ENG-SF21026-R3-CDs.pdf Markup Summary

RD03

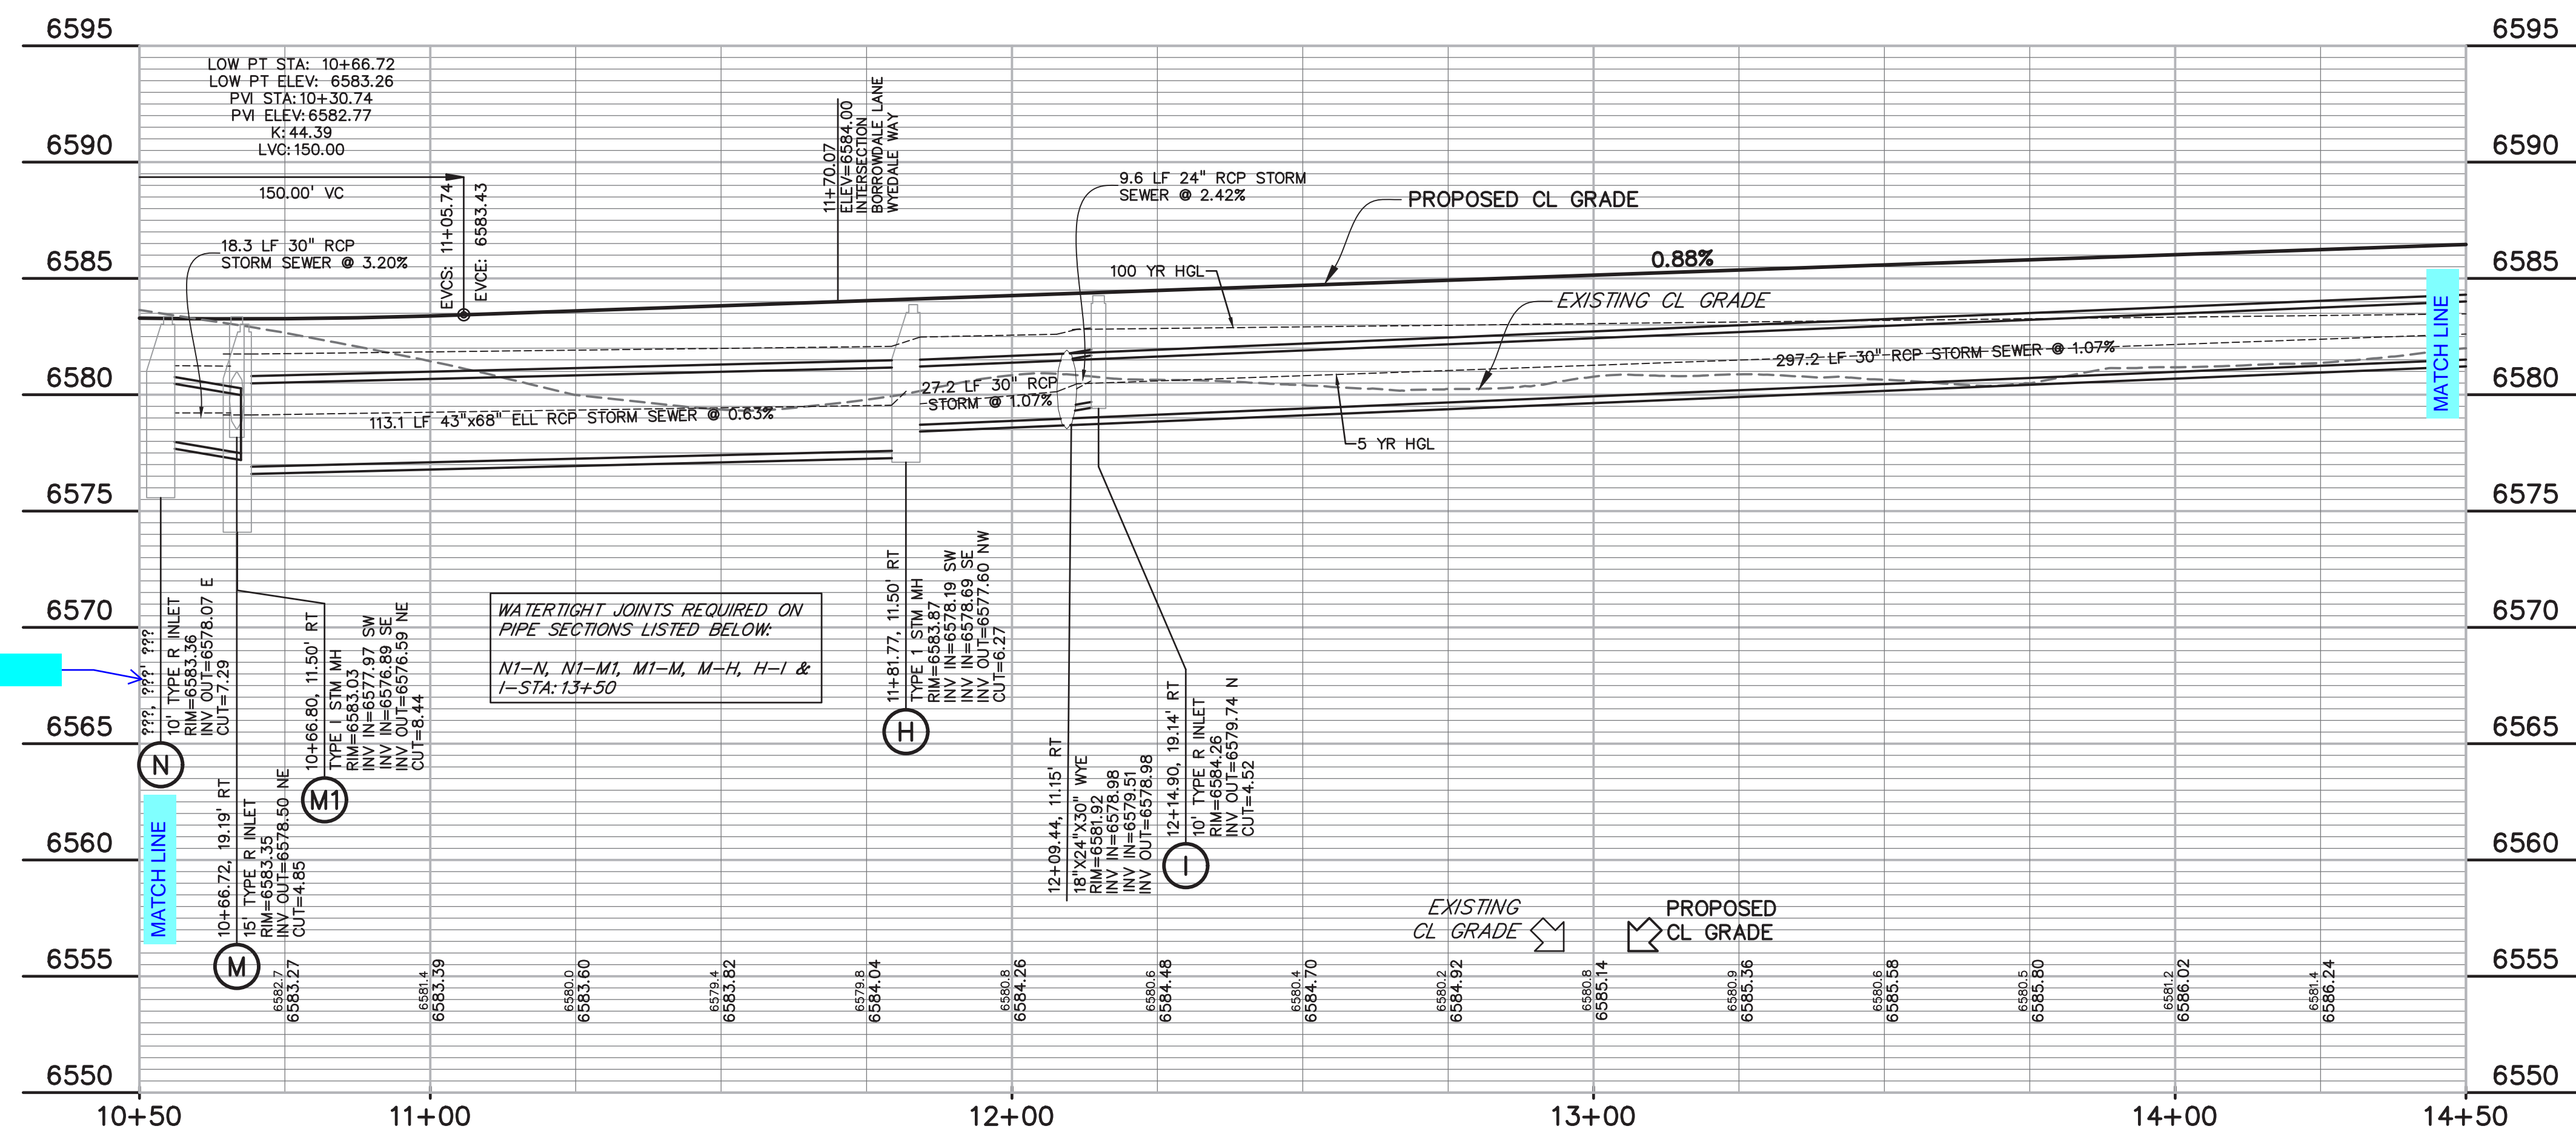
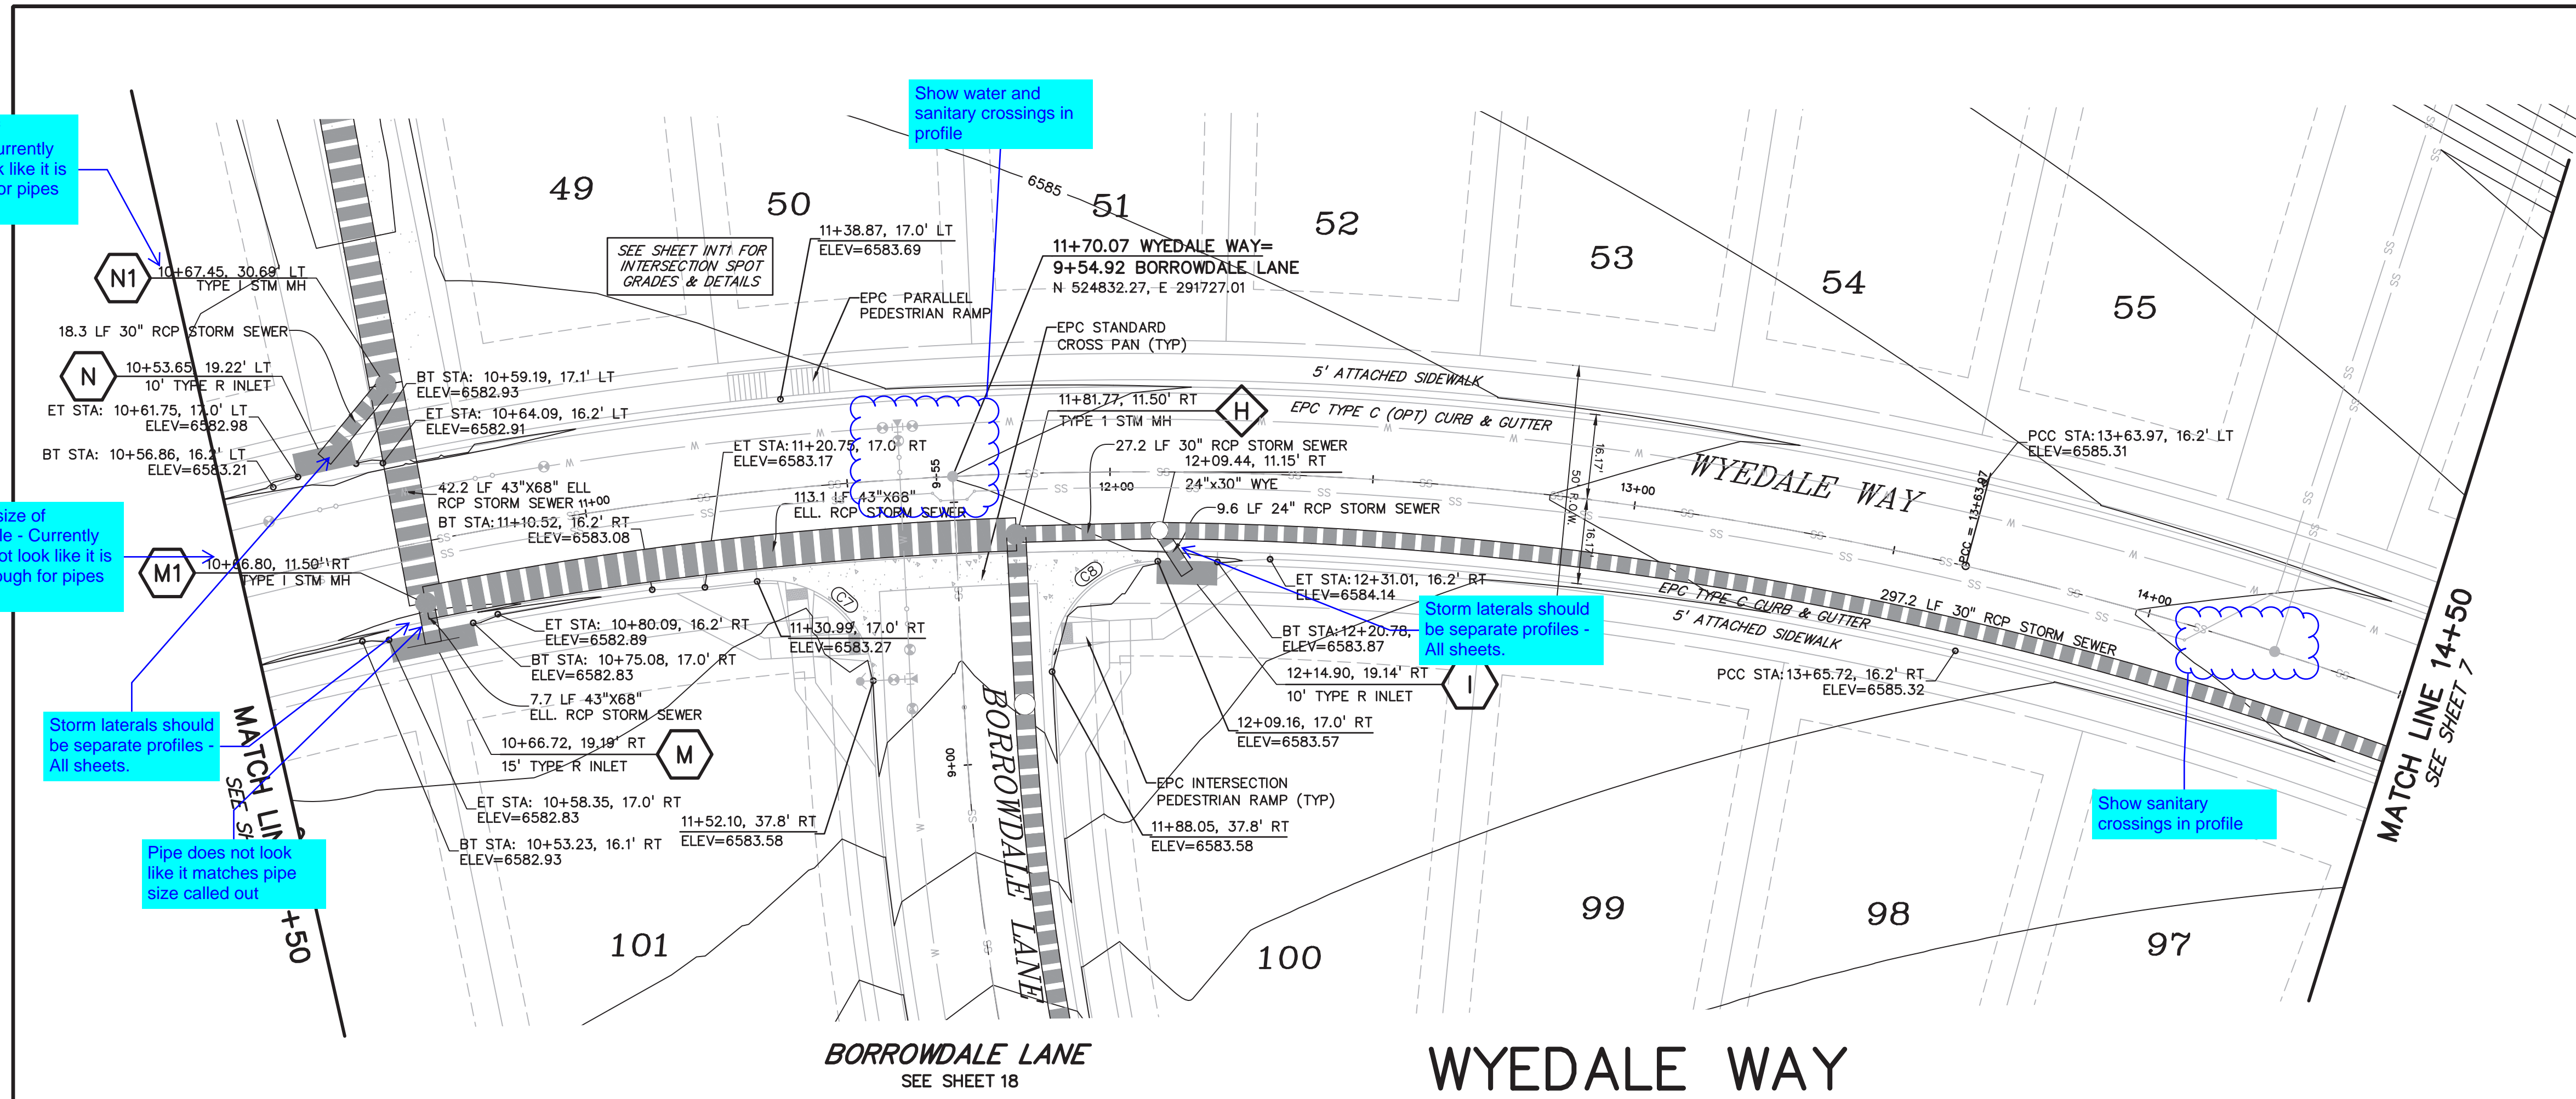
Need to include centerline information for all tangents

Include roadway classification, ROW & design speed - all roadway sheets

Show & label sight distance at all intersections.

SHEET: 8 OF 29

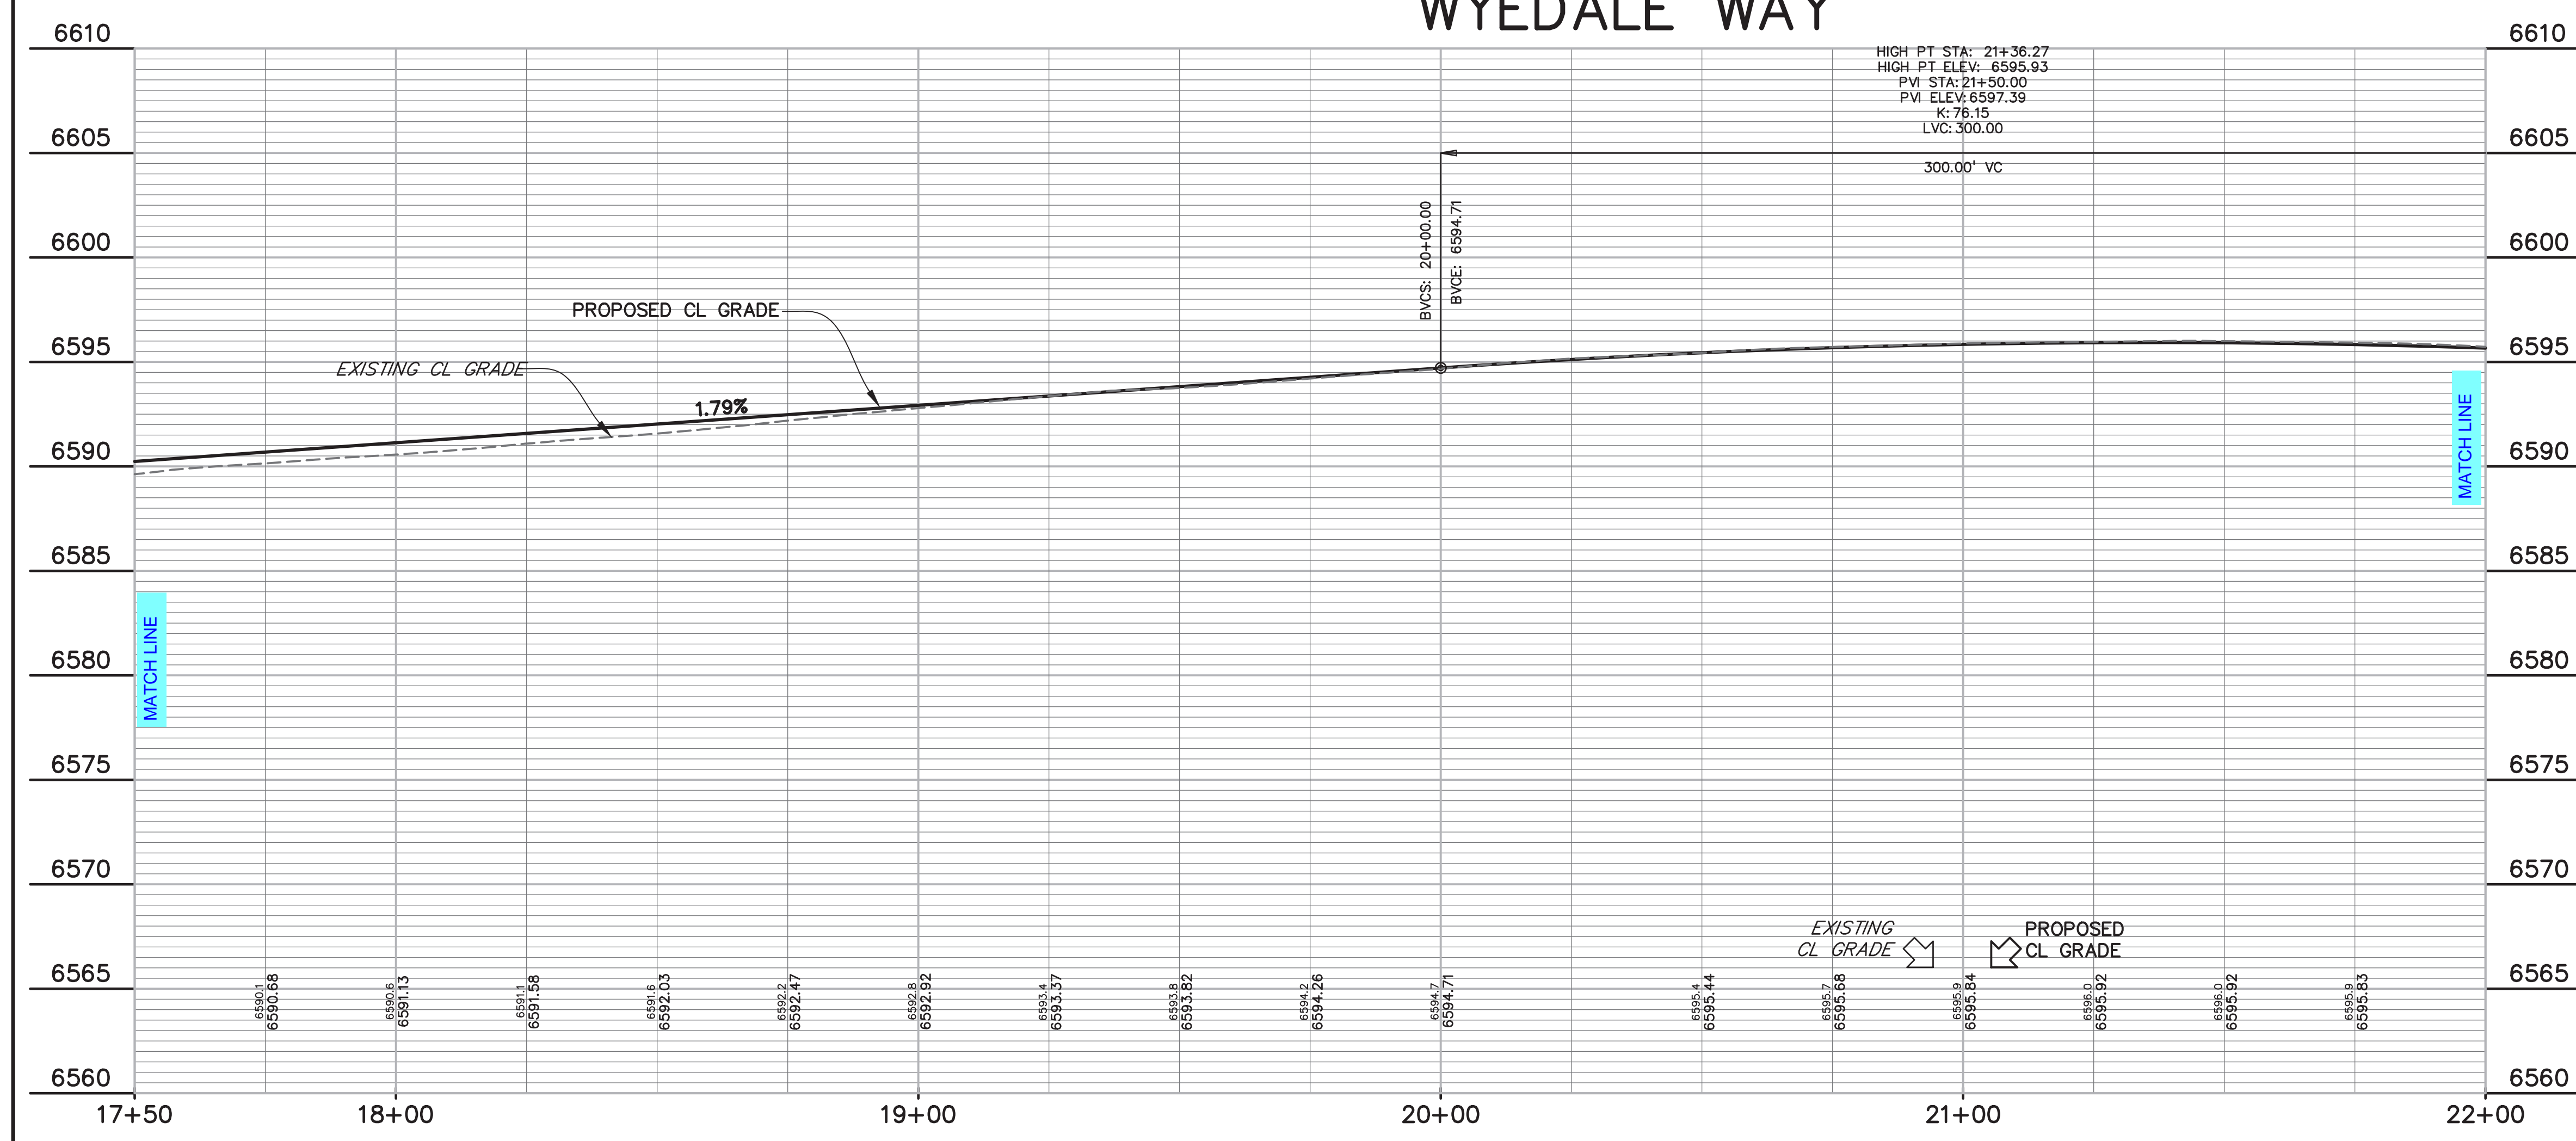
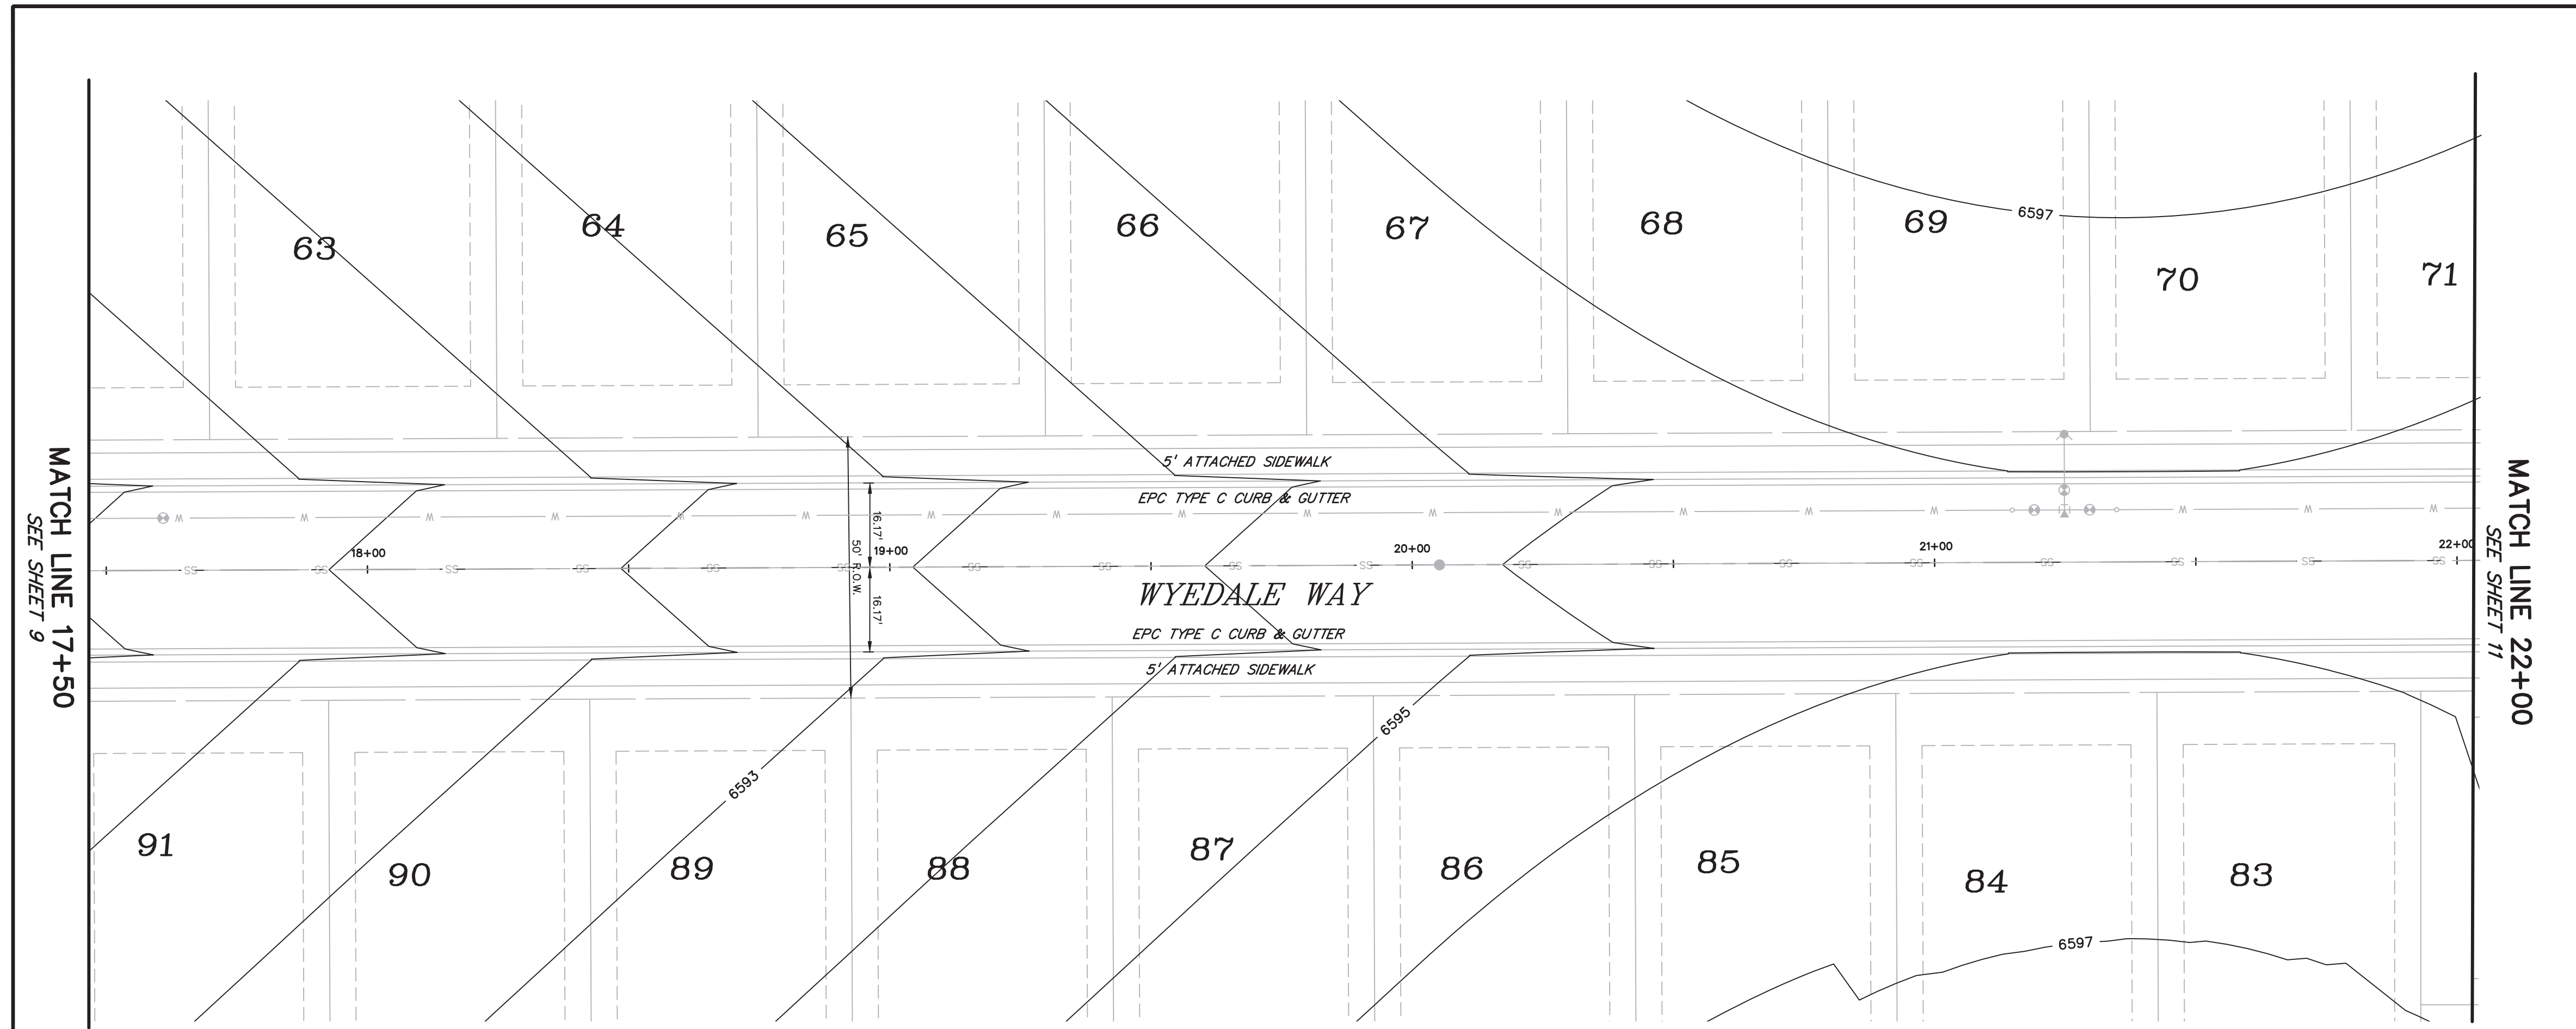
Storm laterals should be separate profiles - All sheets.

Pipe does not look like it matches pipe size called out

Verify size of manhole - Currently does not look like it is big enough for pipes shown.
